From: Melissa Rassack
Sent: Monday, 6 December 2021 6:35 PM
To: Bianca Thornton
Cc: William Hodgkinson; Jane Grose
Subject: RE: Notification of Modification Application - Kemps Creek Mod 2 (SSD-9522-Mod-2)

Thank you for providing Central (Western) with the opportunity to comment on SSD-9522-Mod-2. The following comments are made for your consideration:

DRAWING TITLE
STATE SIGNIFICANT DEVELOPMENT
APPLICATION PLAN

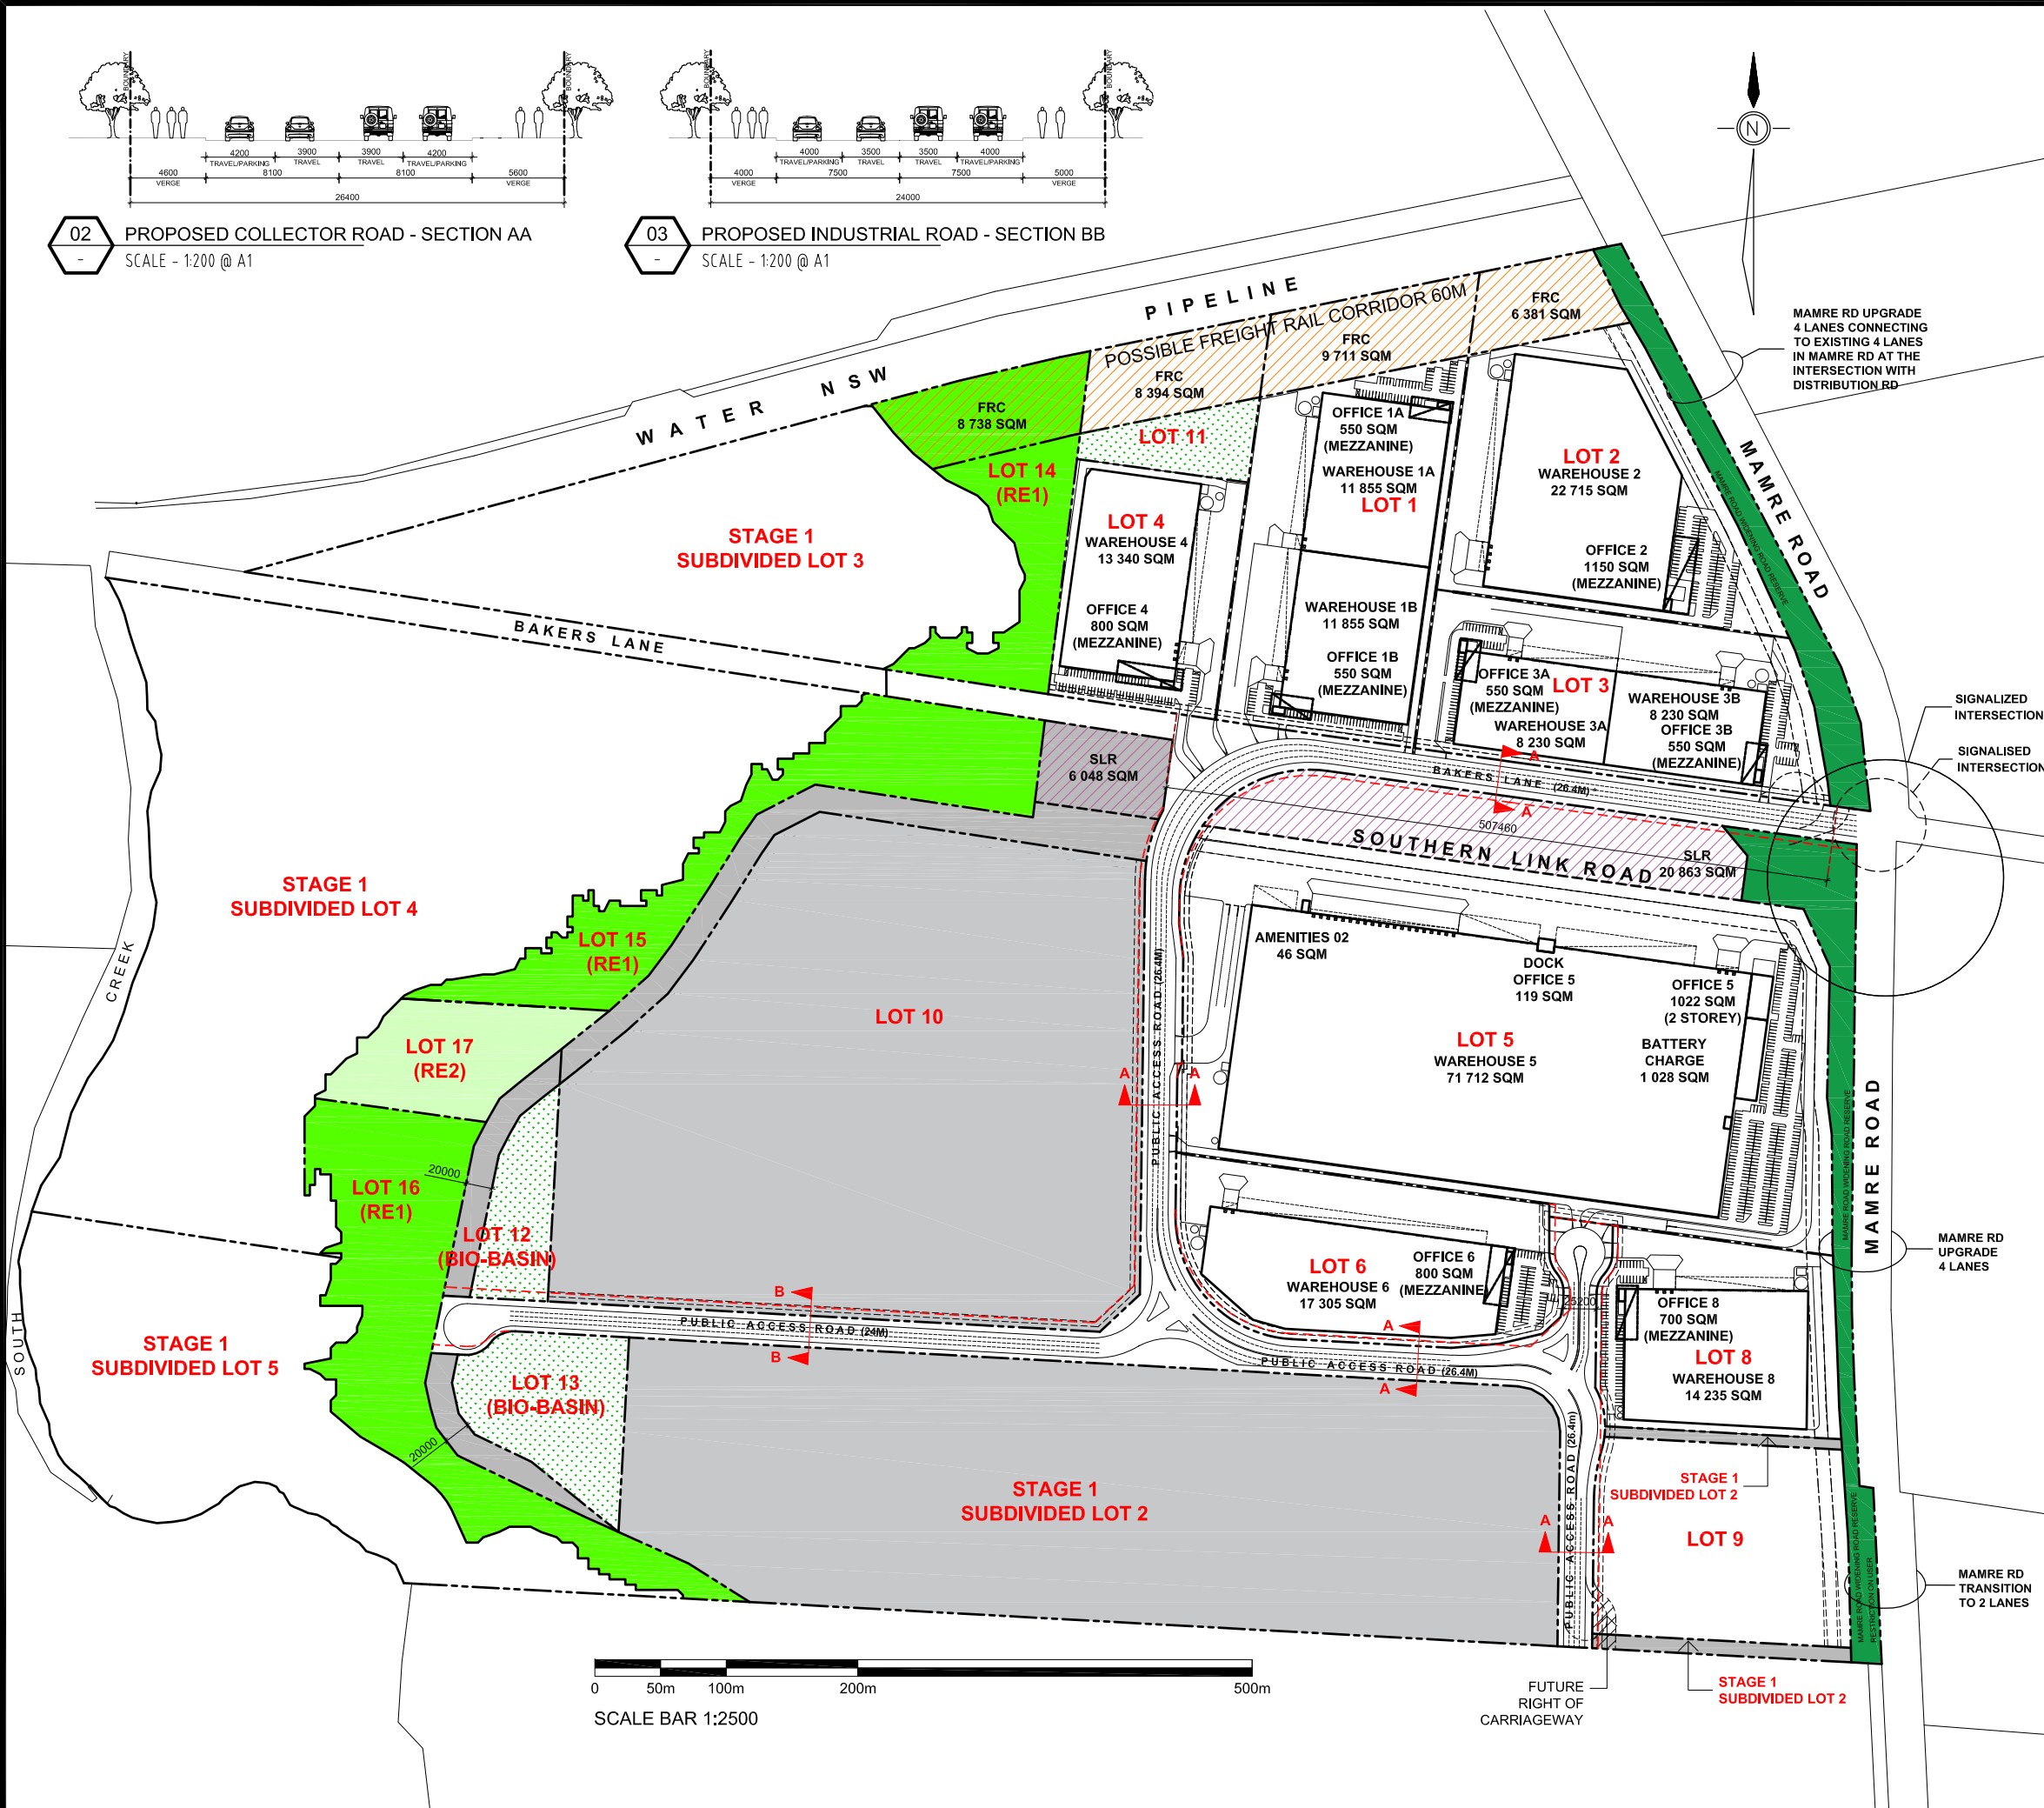
- Road widths and design proposed by SSD-9522-Mod-2 must comply with the Mamre Road Precinct Development Control Plan 2021.
- The proposed revised road widths should ensure that the buildings within the development comply with the landscape setbacks established within the Mamre Road Precinct DCP 2021.
- DPIE's Chief Engineer should be consulted with respect to road safety and the design of the north-south road.
